**RE: Coronado Village – Water Tank
Grading and Drainage Plan
Stamp Date: 11/16/17
Hydrology File: C18D017**

Based upon the information provided in your submittal received 11/16/2017, the Grading and Drainage Plan **is not** approved for Building Permit. The following comments need to be addressed for approval of the above referenced project:

NEW STORAGE TANK
GRADING PLAN

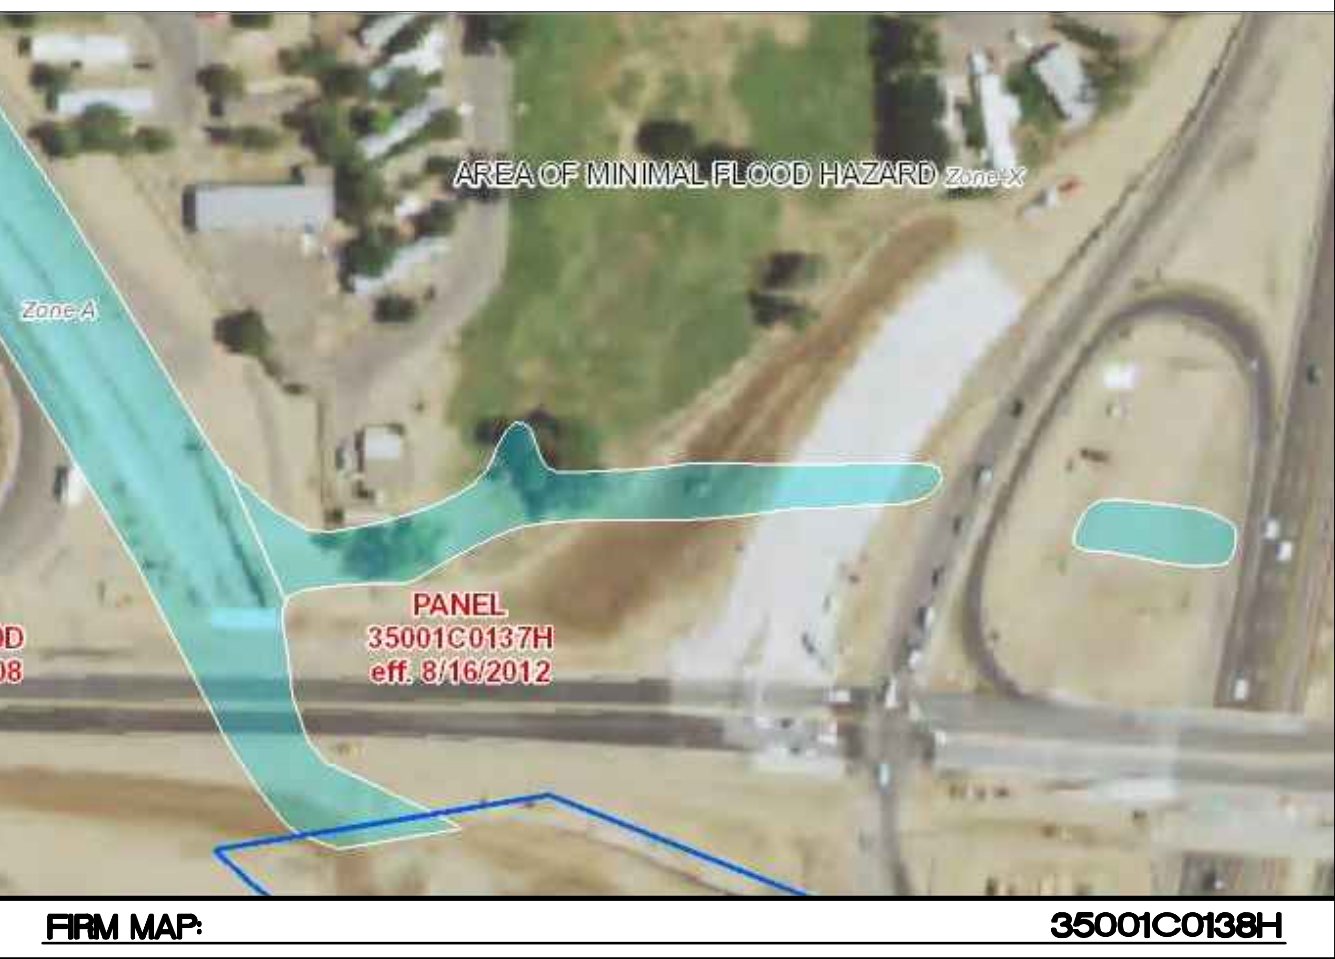
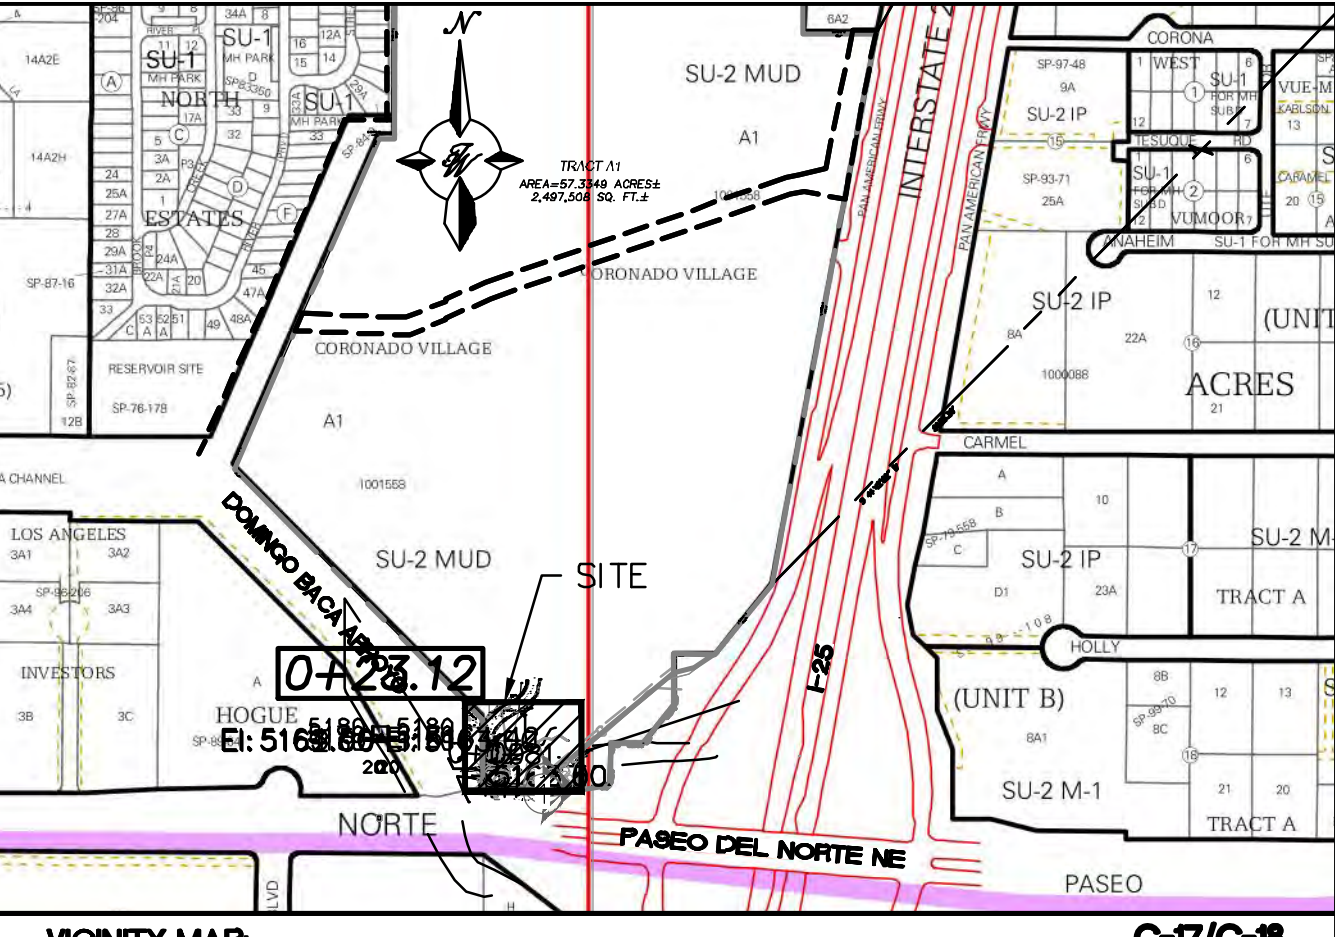
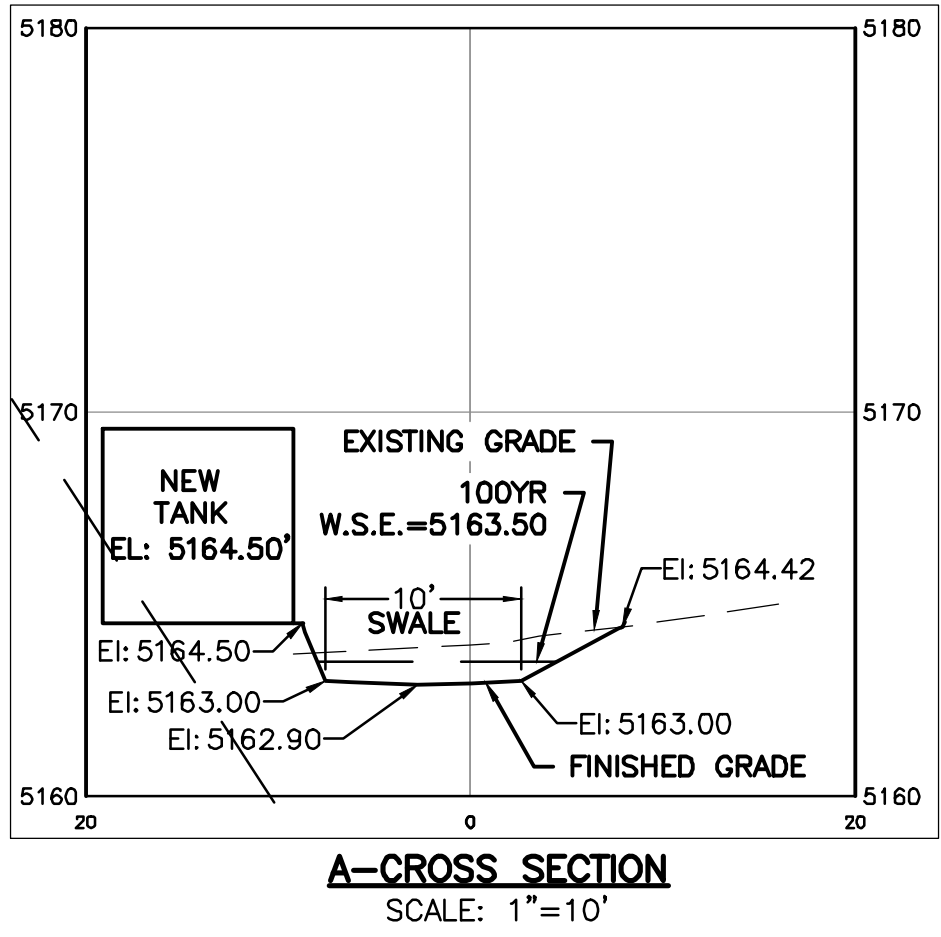
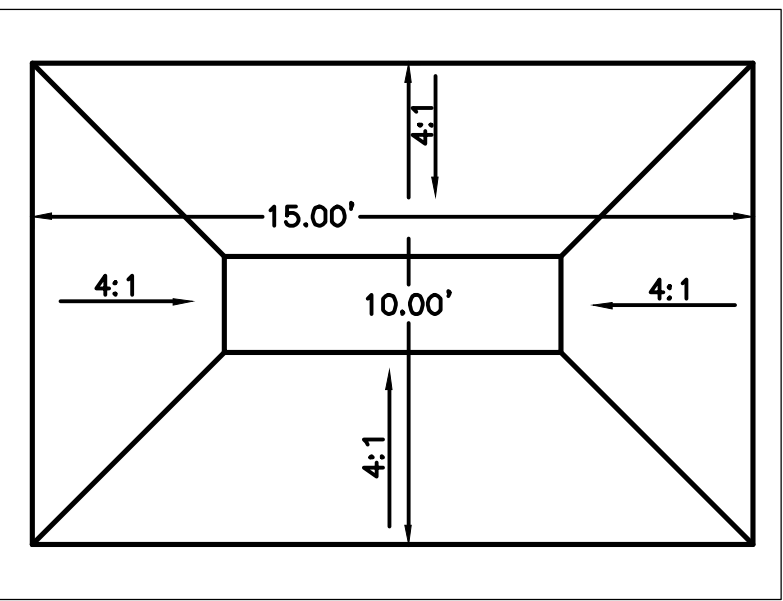
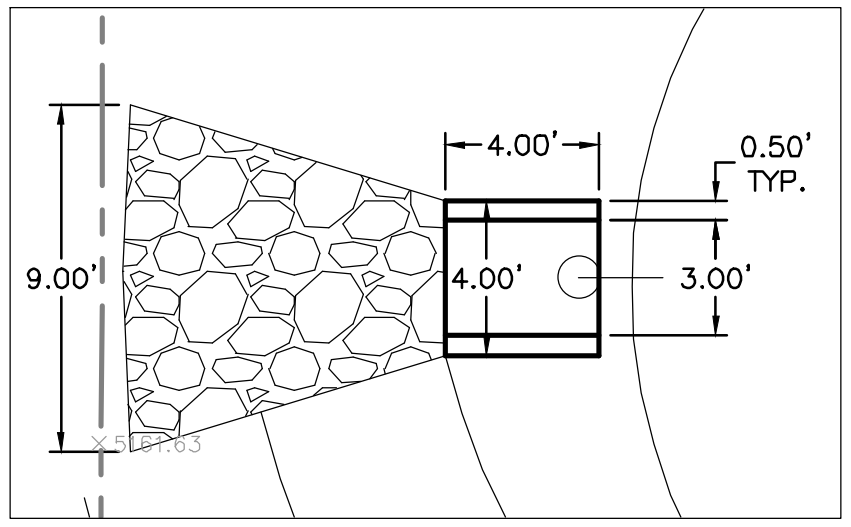
1. Please show and label the flood plain “AO” on the Grading Plan.
2. Please provide the benchmark information for the survey contour information provided.
3. Please relocate the first flush pond. It needs to be directly downslope of the proposed tank so that the runoff goes into it prior to running down the concrete channel rundown to the North Diversion Channel.
4. Please either relocate the proposed new tank out of the “AO” flood plain or raise the pad elevation one foot above the 100 year elevation for this “AO” flood plain. This 100 year elevation may have to be calculated.
5. If the location of the proposed new tank is to remain, then please create a diversion swale around the tank to allow the existing runoff flow the concrete channel rundown to the North Diversion Channel and not have the proposed new tank be a blockage for the existing drainage flow.
